From: David Fuller [REDACTED]
Sent: 01 June 2015 09:53
To: Ross Leal
Cc: AFA Fuller
Subject: K/17/15/HH - Russet House, Gorse Avenue, Kingston Gorse

Further to our discussion on Friday (29th), please see below responses below addressing the concerns raised in a letter dated the 19th May (attached) from Mr & Mrs Millet, the immediate neighbours at Scesaplana to the East of Russet House.

Drawing No
15753/ 02

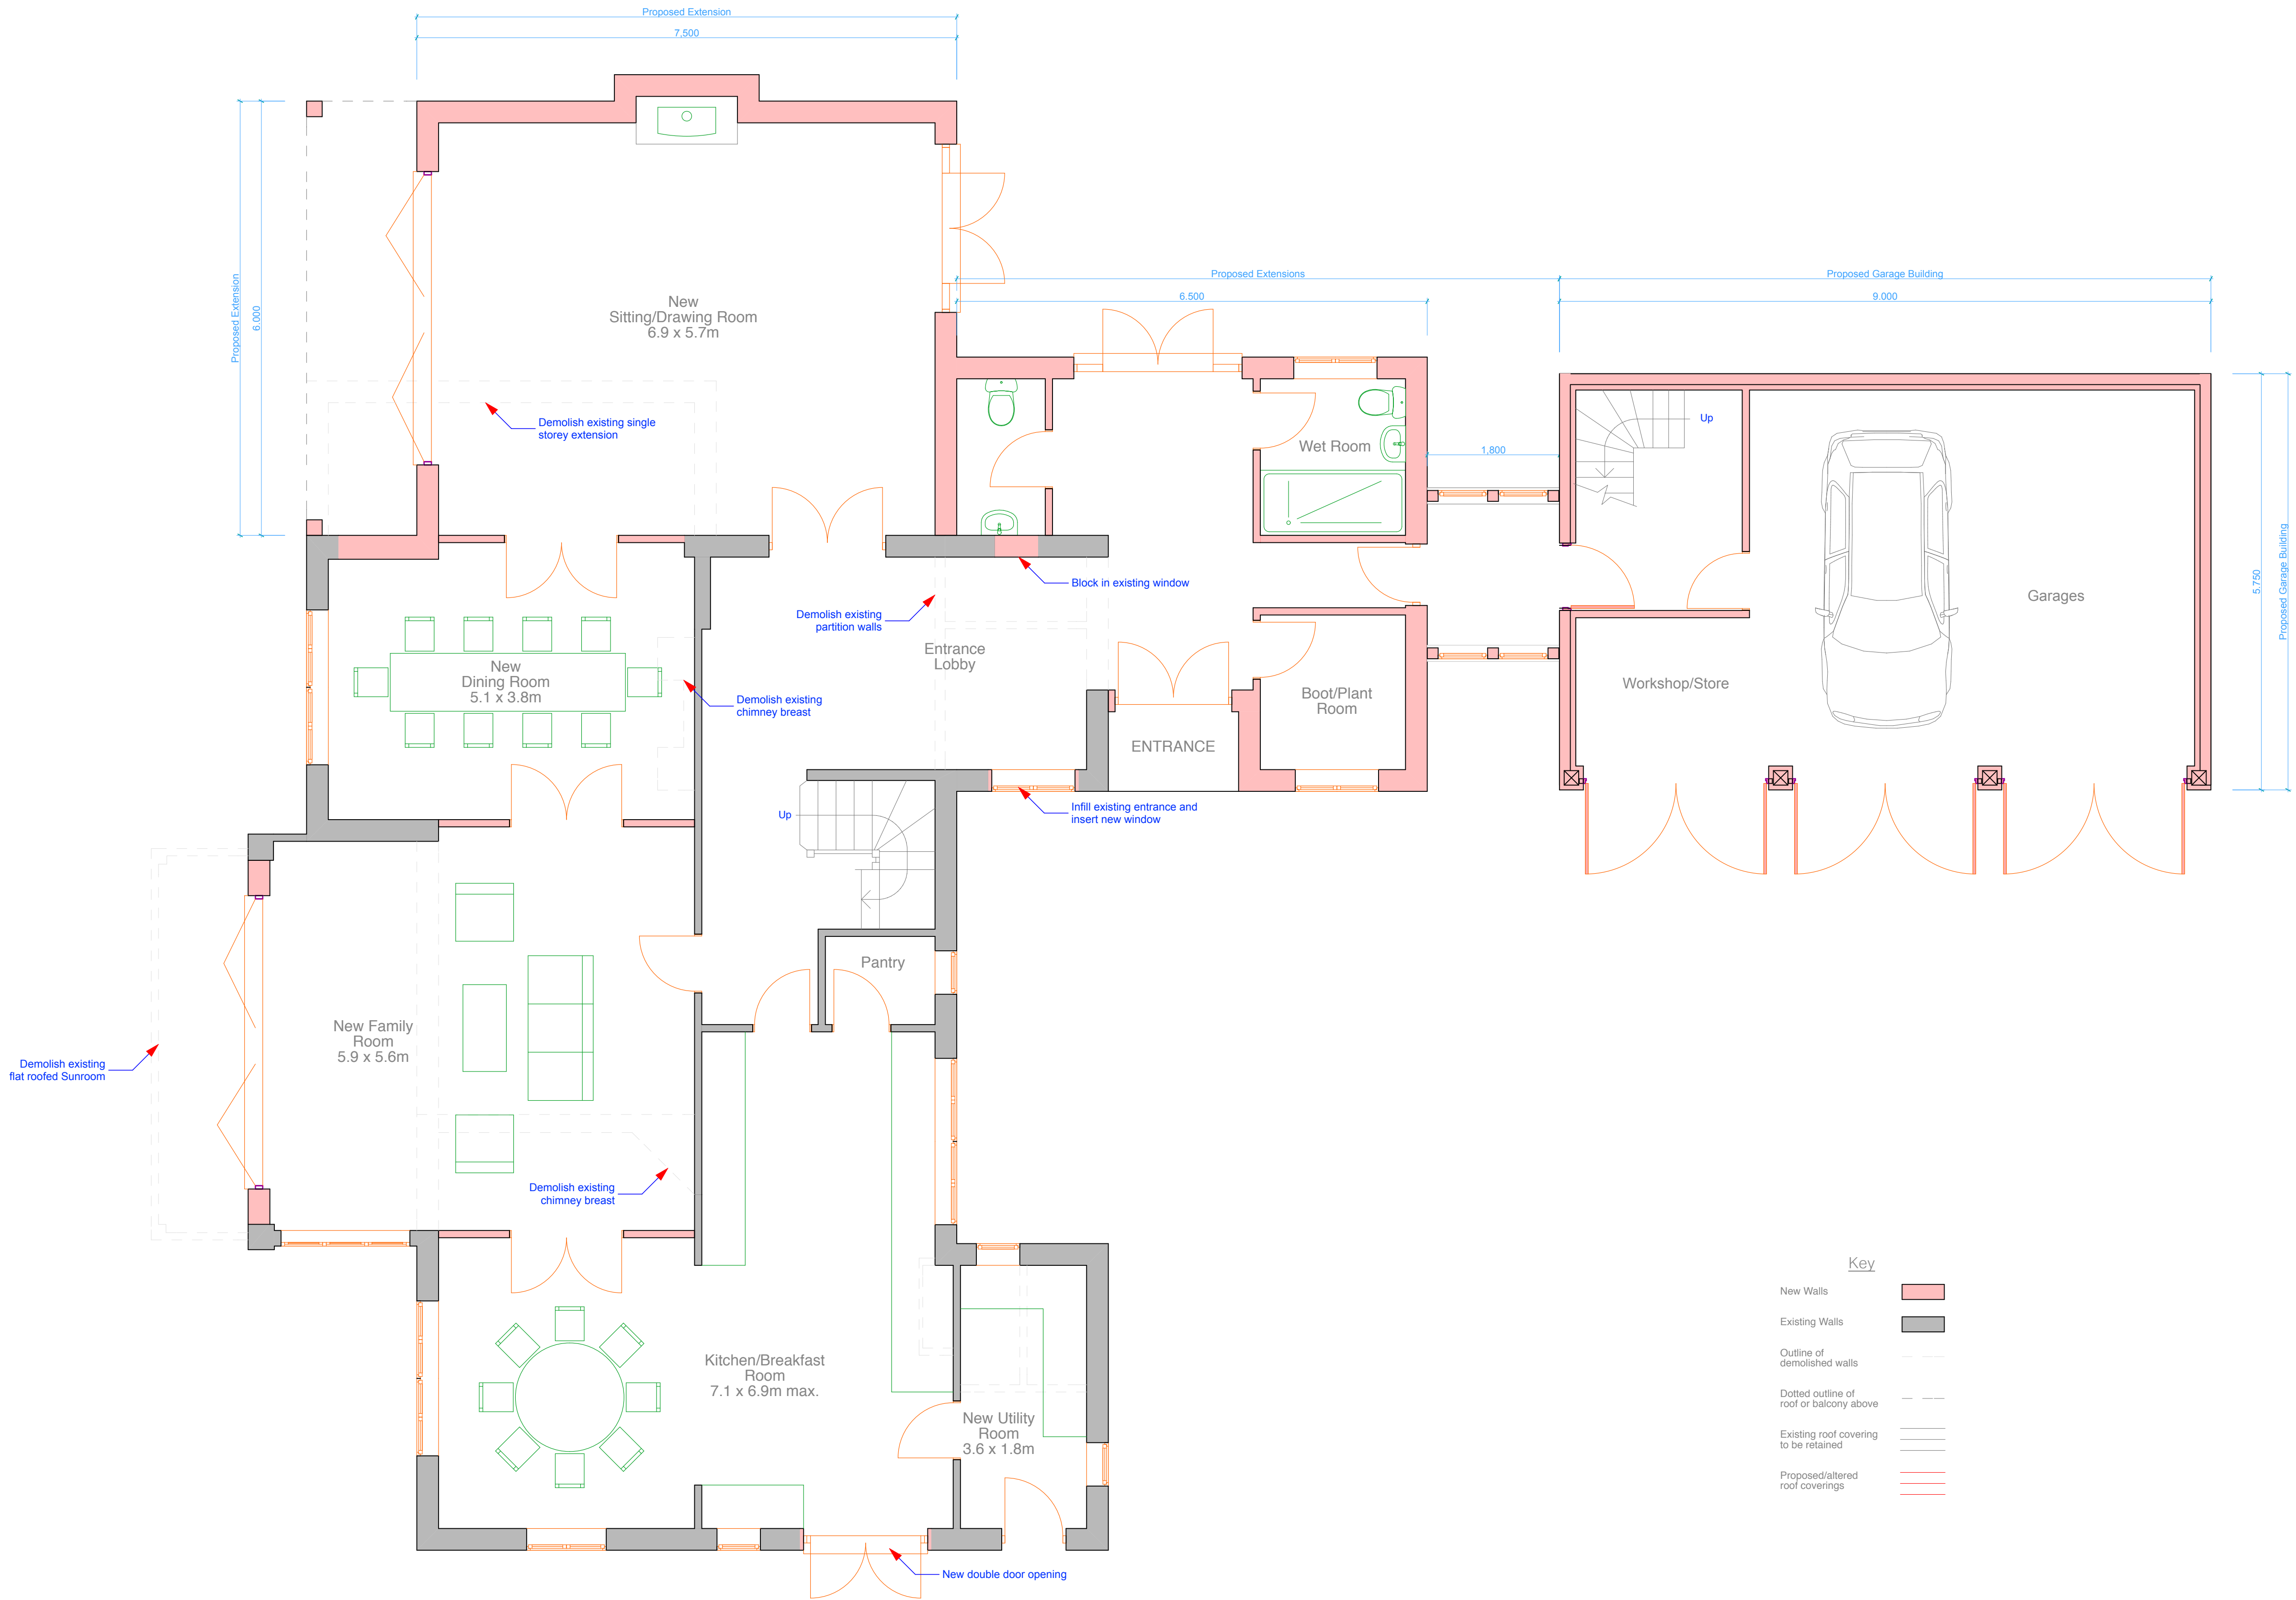
3. Ref. Swimming Pool, generally, when used, are a source of noise and are unacceptable if not well monitored, basically we object to a pool, especially as we already have two in close proximity.

3) The proposed swimming pool is well shielded from the objecting property by the proposed link extension and Garage building. In addition, fencing and hedging/tree foliage will provide additional shielding from any noise nuisance that may arise. Also, as Mr and Mrs Millet mention in their letter, many of the properties immediately surrounding Russet House have outdoor swimming pools - they are an established feature of the area.
